Examining Authority's Second Written Round of Questions and Requests for Information Response from Thames Water

**Code of Construction Practice Part B: Site Specific Requirements
- Barn Elms (Comparite against 28 February 2013)**

Doc Ref: **APP72.4**

Barn Elms

**Figure 1.1 Barn Elms: Site context and location plan**

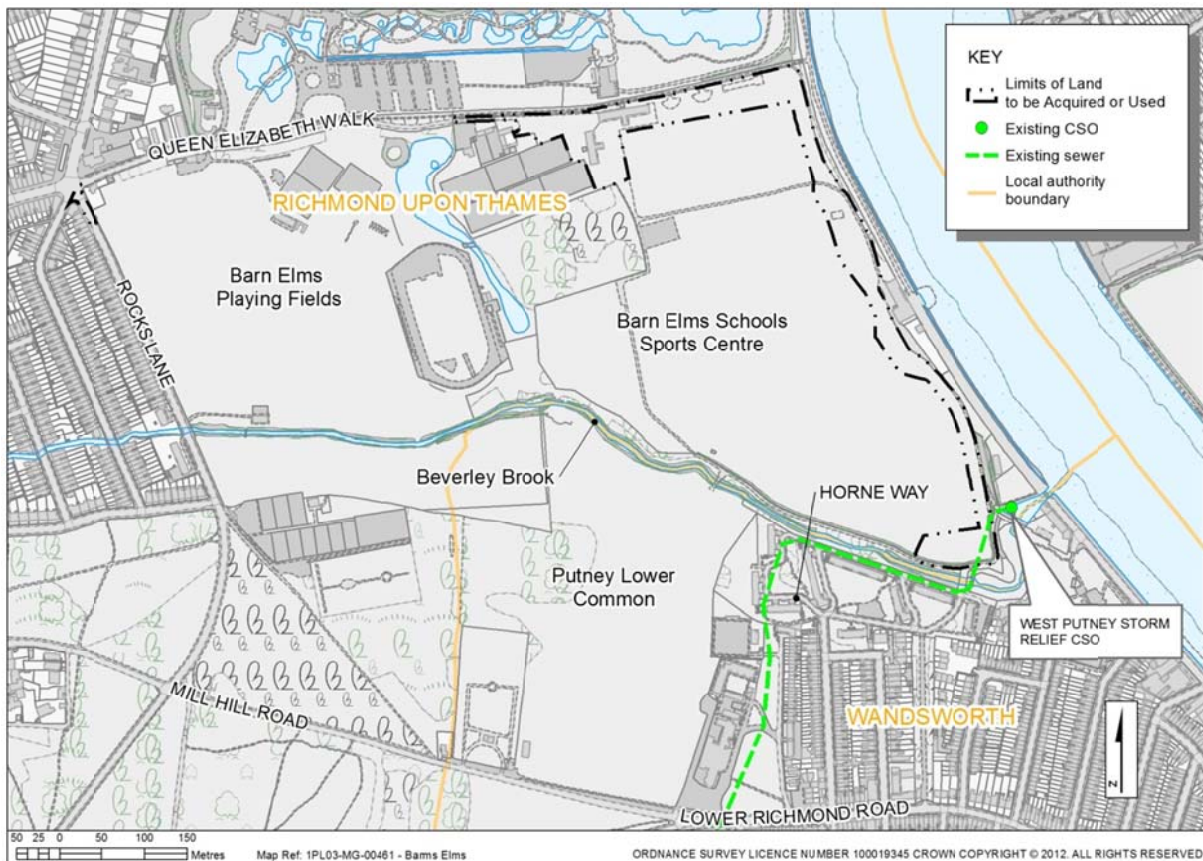
4 Site operation	
Topic	Site-specific requirement
Working hours	<p>This site will<u>shall</u> adhere to the following working hours.</p> <ol style="list-style-type: none"> a. standard b. continuous (for the West Putney connection tunnel construction). <p>Other<u>When other types of working hours are (CoCP Part A, Table 4.1) are required, these shall be subject to agreement with the local authority through the Section 61 process.</u></p>
Site layout	<p>Operating plant and equipment will<u>shall</u> be set back from the bank of the Beverley Brook to leave an 8m buffer zone, unless agreed otherwise.</p>
Site security / hoarding requirements	<p>The main site compound is to be fully hoarded. A buried fencing / steel mesh netting will<u>shall</u> be extended at least 500mm below the hoarding to prevent badgers, etc from accessing the working site (see Section 11).</p> <p>The access route will<u>shall</u> have green painted steel open mesh fencing suitably supported for weather conditions or similar and will<u>shall</u> be designed to allow badgers, etc access across the road at night.</p> <p>The hoarding is to be as defined in CoCP Part A Section 4.3.4c, planted hoarding on public facing sections.</p> <p>The hoarding height is to be 3.6m at this site.</p>

<u>River works</u>	<u>As per text in CoCP Part A.</u>
Other items	<p>High pole suspended vertical netting of sufficient height will<u>shall</u> be erected above the hoarding where required to prevent balls from entering the hoarded construction works from the playing field.</p> <p>Site cabins and welfare facilities to be dark green color to tie in with the planted hoardings.</p> <p><u>The use and duration of the construction areas within the Barn Elms Schools Sports Centre are to be minimised and reduced, as appropriate, between the construction phases. This includes reducing the construction site area used after completion of the main civil engineering works, including shaft construction, but prior to mechanical</u></p>

Topic	Site-specific requirement
Site access and gates	<p>The site access/egress willshall be from Upper Richmond Road (A205), travelling along Rocks Lane (A306) and turning right into Queen Elizabeth Walk. Vehicles willshall access the site via the Barn Elms Schools Sports Centre car park. A new access road willshall route along the northern boundary of the sports centre to the River Thames and then along the eastern boundary parallel to the river. The access route design willshall minimise the impact on the existing ecology where practical. It willshall be single track with passing places.</p> <p>Access and construction activities willshall be minimised during times of heavy recreational use of the playing fields.</p> <p>Access to the existing car park and sports facilities willshall be maintained throughout the works.</p> <p>EA emergency access to Ashlone Wharf tidal barrier will be retained. The Contractor shall provide vehicular access to Ashlone Wharf tidal barrier, for the EA and its contractors along the access route to be constructed on the northern and eastern perimeter of Barn Elms Playing Field, for the duration of the works.</p> <p>The entrance to the access route shall be kept secure at all times, whilst ensuring that the EA can access the asset whenever this is required (unrestricted 24hours a day, to ensure that they can fulfil their flood defence obligations).</p>

Topic	Site-specific requirement
	<p>vehicles and pedestrians, unless otherwise agreed.</p> <p>Parking changes within the Sports Centre car park required to facilitate the construction site access road, will<u>shall</u> include temporary relocation/ re-provision of car parking spaces for the duration of the works (note: land may be available from the London Borough of Wandsworth for the re-provision).</p> <p>Rocks Lane is part of the London Lorry Control Scheme and HGV movements along this road between 9pm<u>21:00</u> and 07am<u>:00</u> Monday to Friday, 1pm<u>3:00</u> to midnight Saturday and all day Sunday would need to be agreed with the Lorry Control Unit.</p> <p>At locations along Queen Elizabeth Walk and at the Sports Centre car park access where carriageway width may not permit two-way vehicle flow for HGVs traffic marshals will<u>shall</u> be required.</p> <p><u>The contractor shall provide safe segregation between the sport facilities and haul road throughout construction in consultation with the local authority and the Barn Elms School Sports Centre Management. This may include considering the suitable design of construction access fencing and or site hoarding to withstand potential impact from sports pitch users.</u></p>

Event restrictions	To be advised from discussions with the London Borough of Richmond upon Thames.
River transport	N/A
Other	<p>Access to the Beverly Brook footpath would be maintained during construction.</p> <p><u>Pedestrian access between Queen Elizabeth Walk and the Barn Elms School Sports Centre shall be maintained. The position of the existing pedestrian access gate in the northern perimeter fence, shall be relocated to reflect the final layout of the construction access.</u></p> <p><u>The position of the relocated pedestrian access gate shall remain in close proximity to the changing room facilities, and access to the facilities shall be maintained throughout the works.</u></p>
